# BEACON FEN ENERGY PARK

Planning Inspectorate Reference: EN010151

Applicant's Response to Other Parties' Deadline 3 Submissions

Document Reference: 9.11

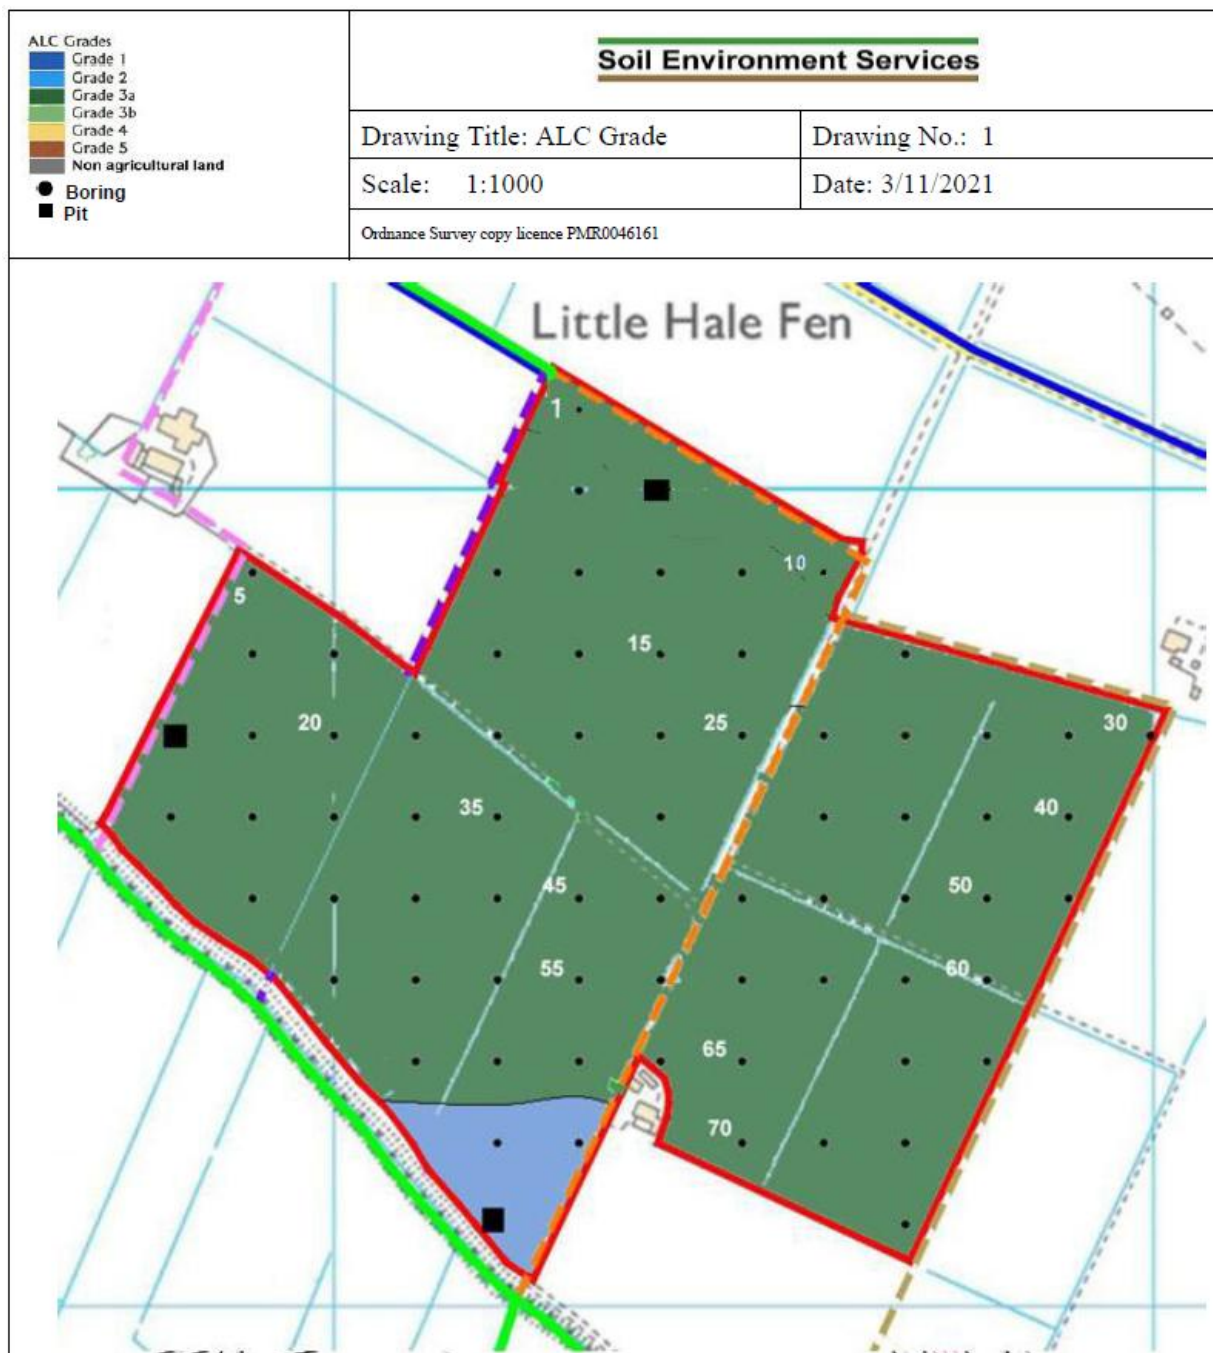
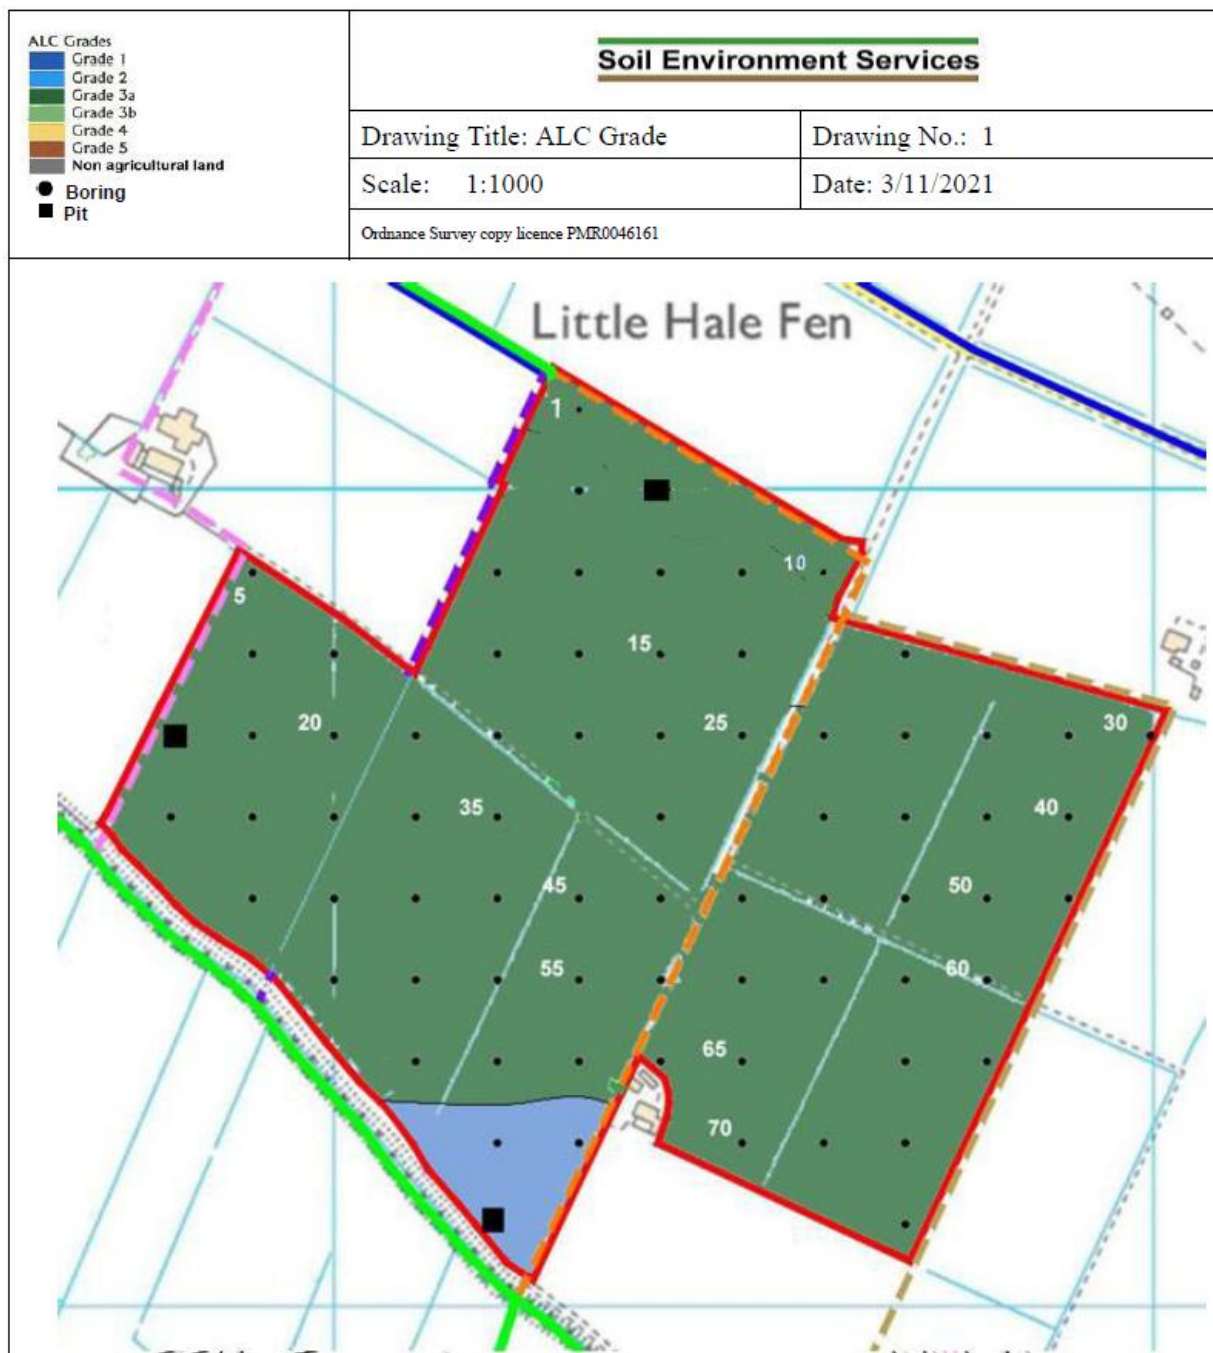
Ex2 in LCJMF's REP1-043 shows soil survey results for the AGR3 site. It shows majority Subgrade 3a, with some Grade 2. The Applicant's desktop data showed this area as within a Grade 2 contour. Therefore, using either the desktop mapping or the survey result, it is comprised entirely of BMV land.

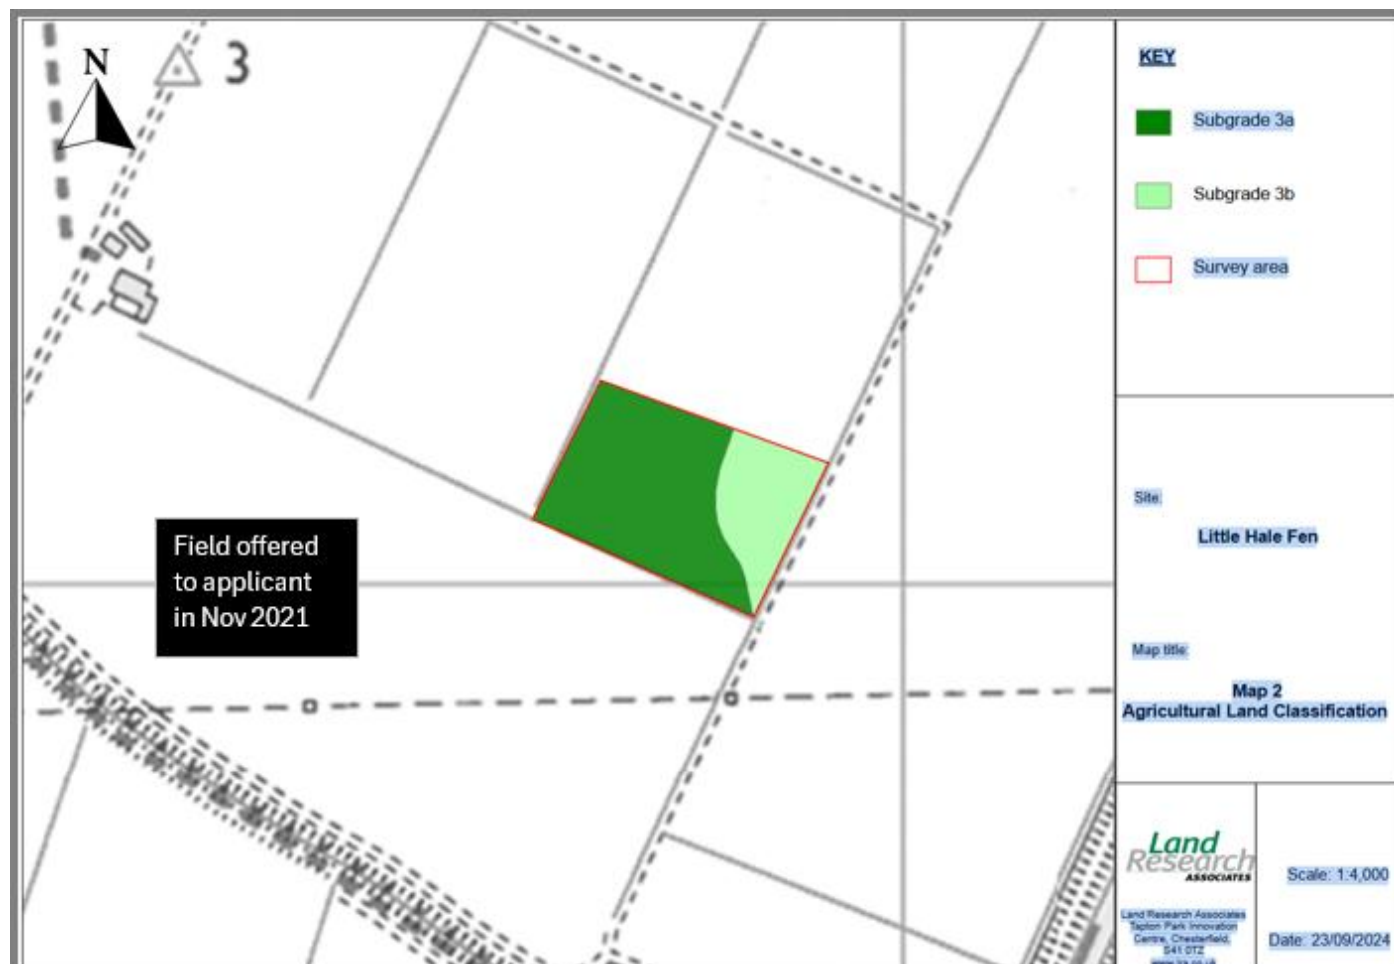
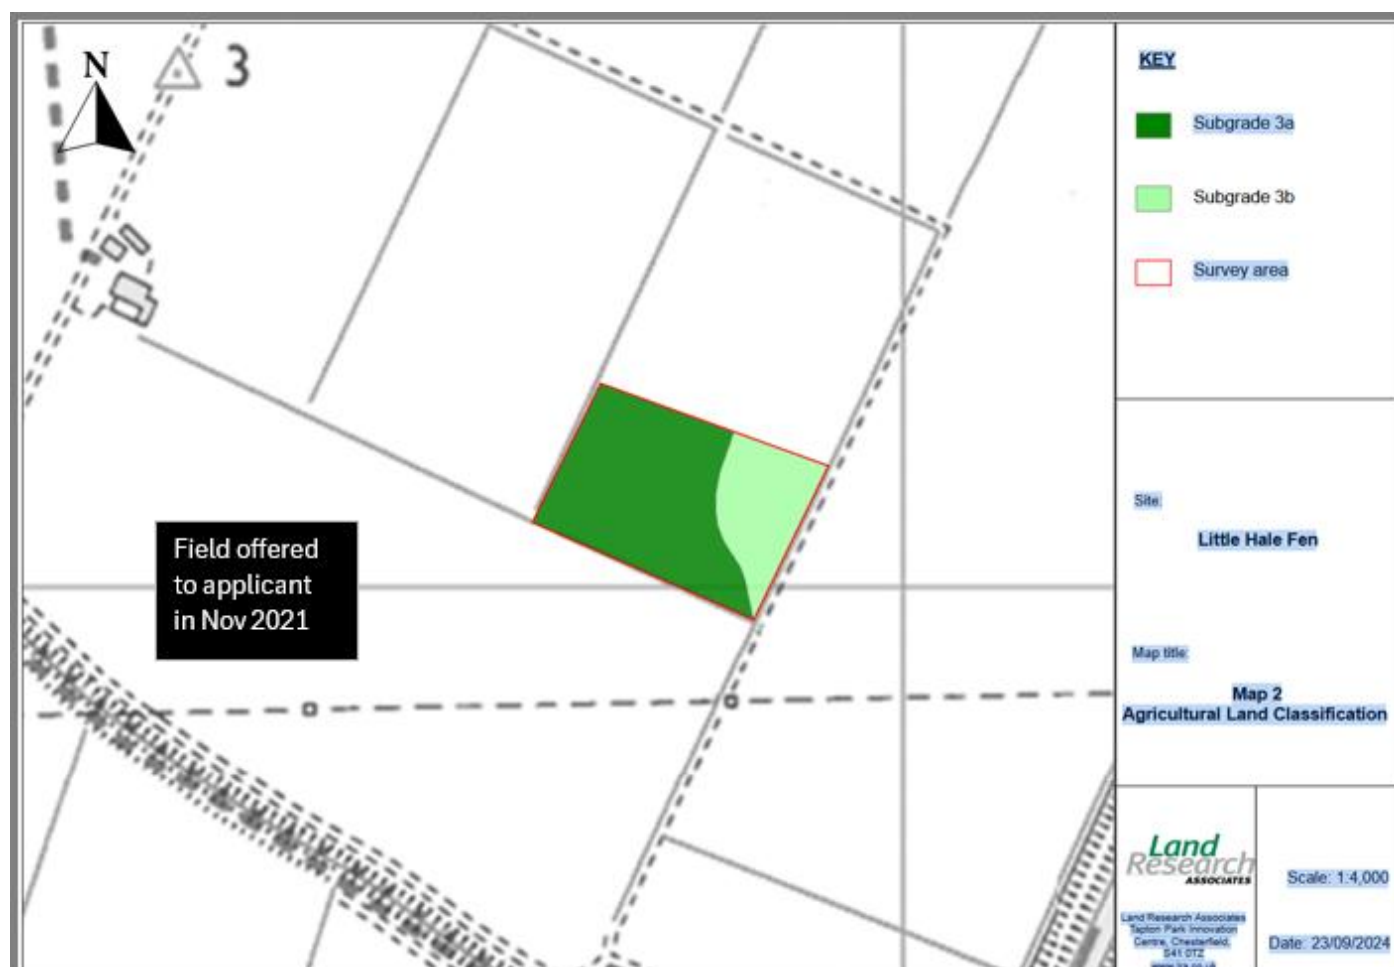
Ex2b is a survey result for a very small field parcel (2.5 ha). This shows majority Subgrade 3a with some Subgrade 3b. Again, this survey demonstrates that the land is predominantly BMV (albeit at a lesser grade than the desktop mapping).
